CITY OF PORTLAND

BUILDING PERMIT

Job ID: 2011-12-2854-ALTCOMM

has permission to Remove existing Porch replace w/ smaller porch
provided that the person or persons, firm or corporation accepting this permit shall comply with all of the provisions of the Statues of Maine and of the Ordinances of the City of Portland regulating the construction, maintenance and use of the buildings and structures, and of the application on file in the department.

**PORCH
SECTION/
ELEVATION**

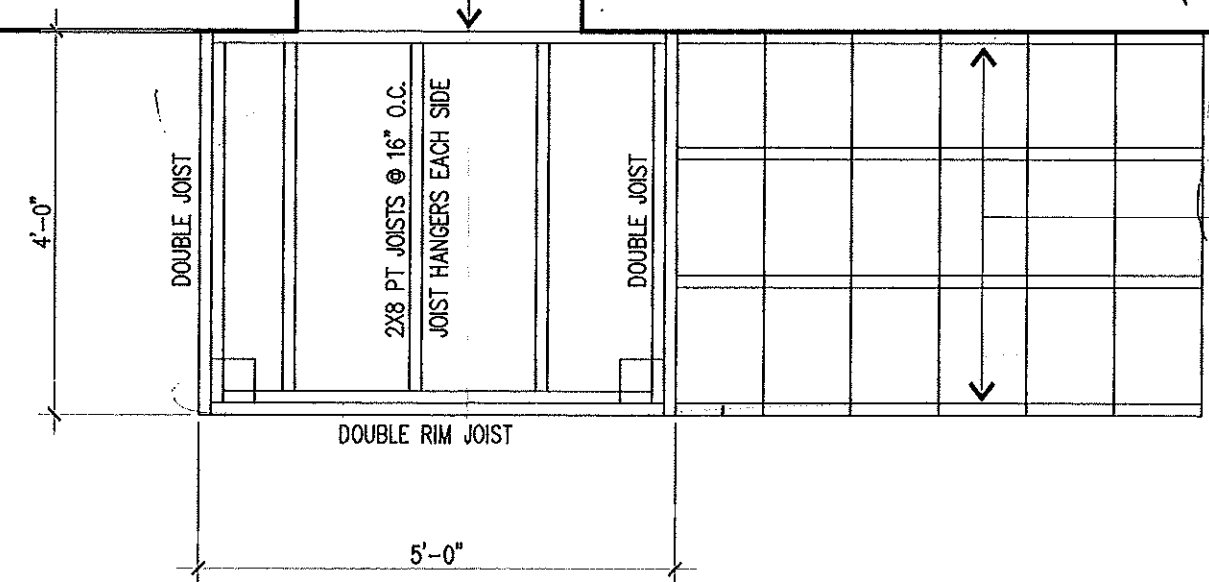
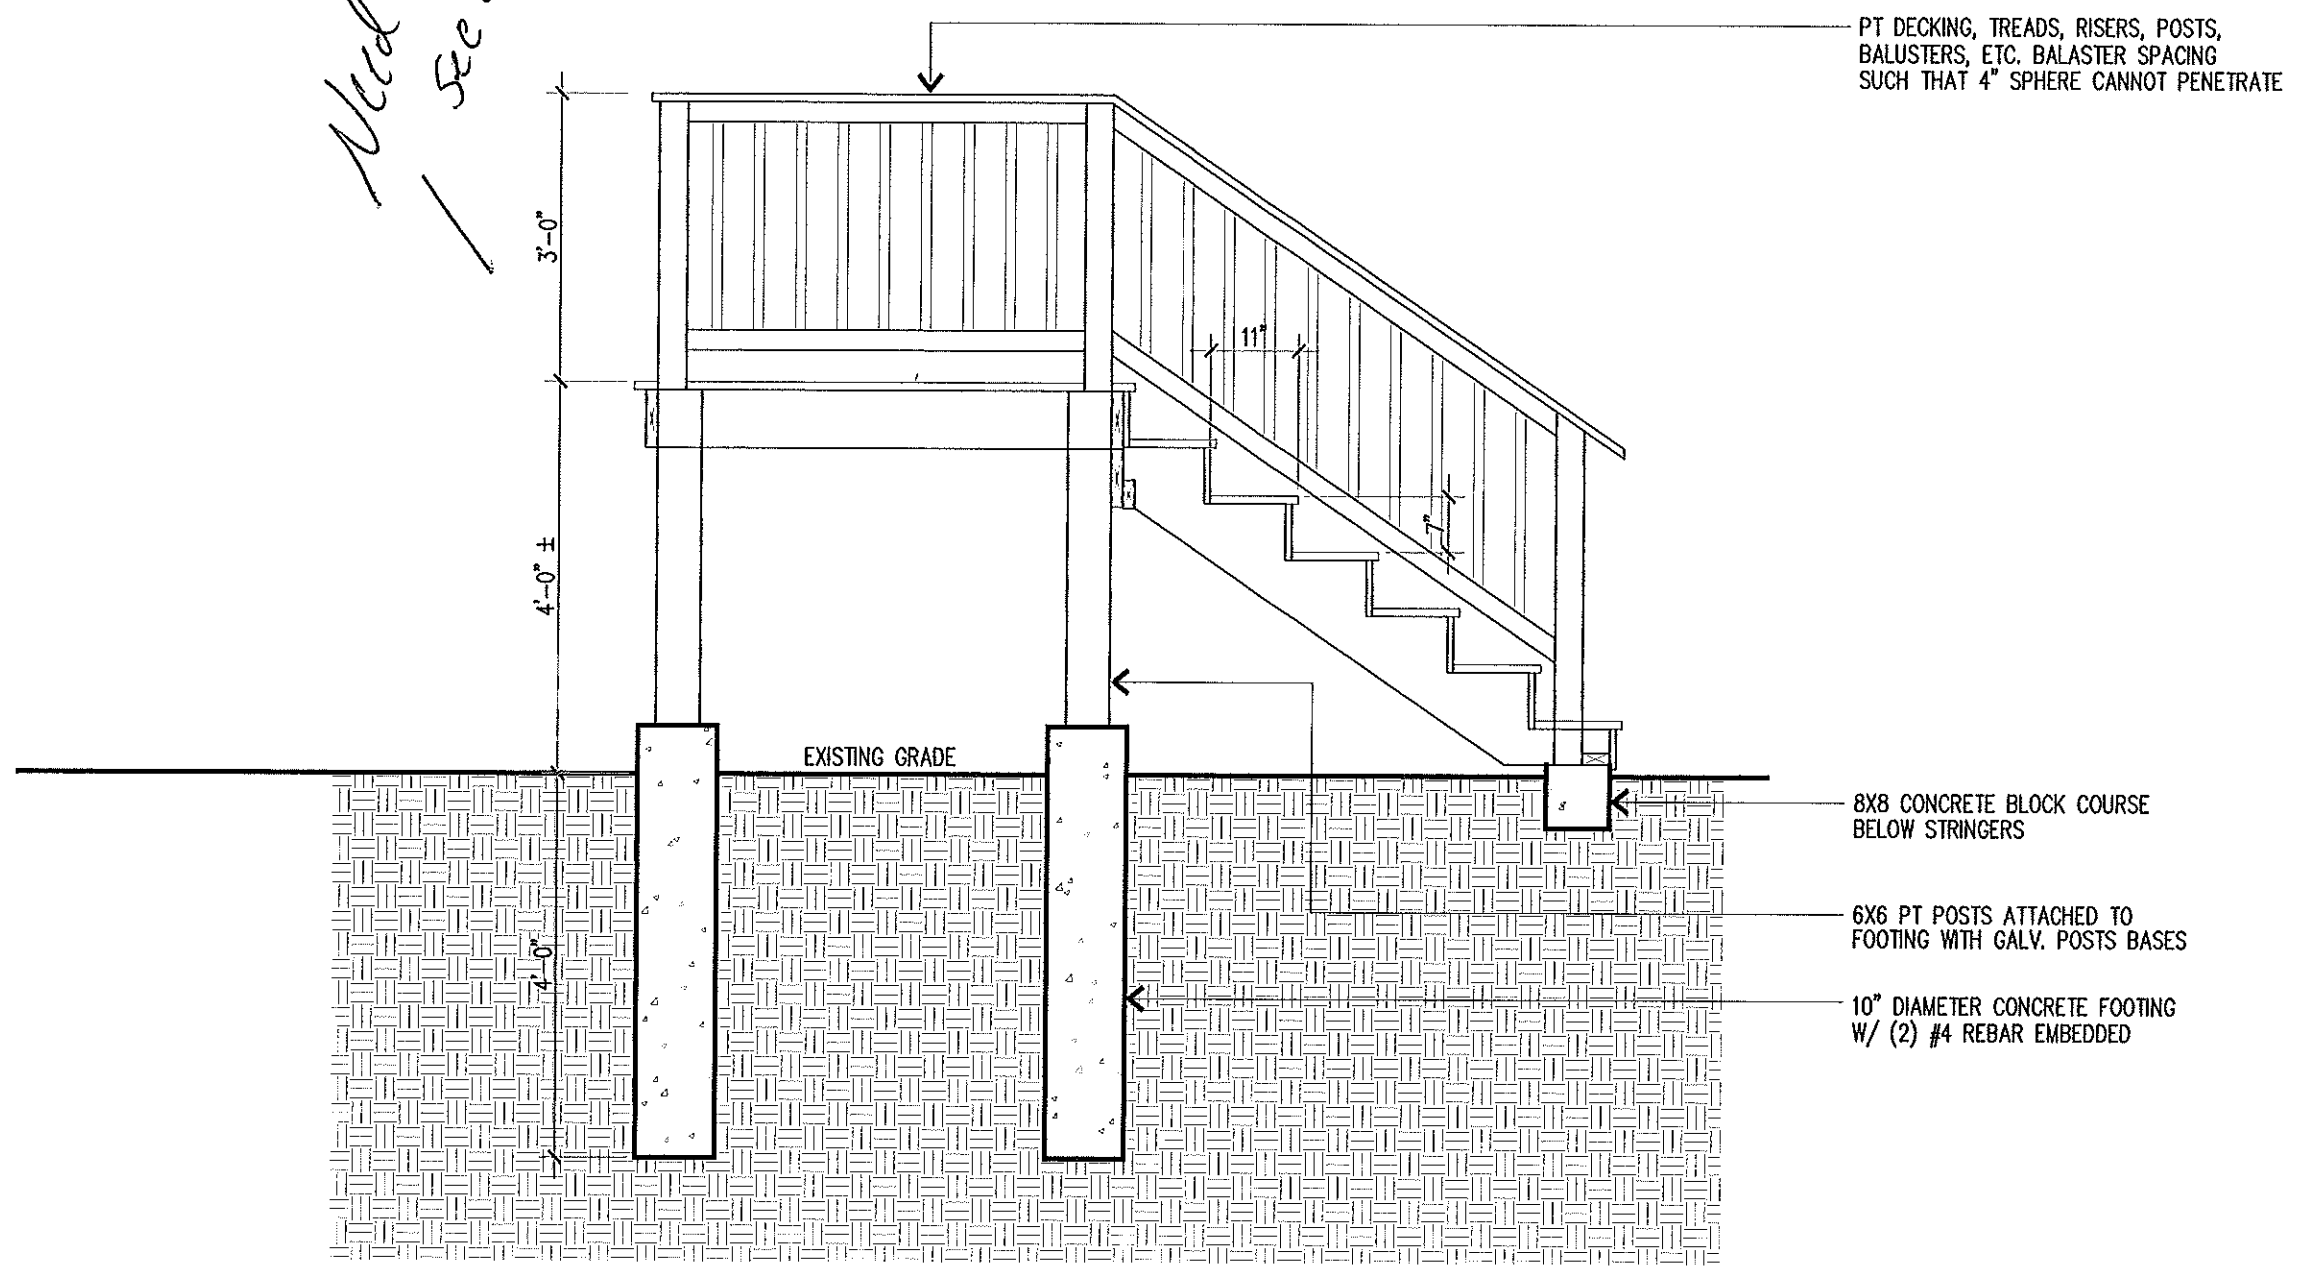
1. Application approval based upon information provided by applicant. Any deviation from approved plans requires separate review and approval prior to work.
2. The guardrail height SHALL BE 42" NOT 36" as shown on the plans.
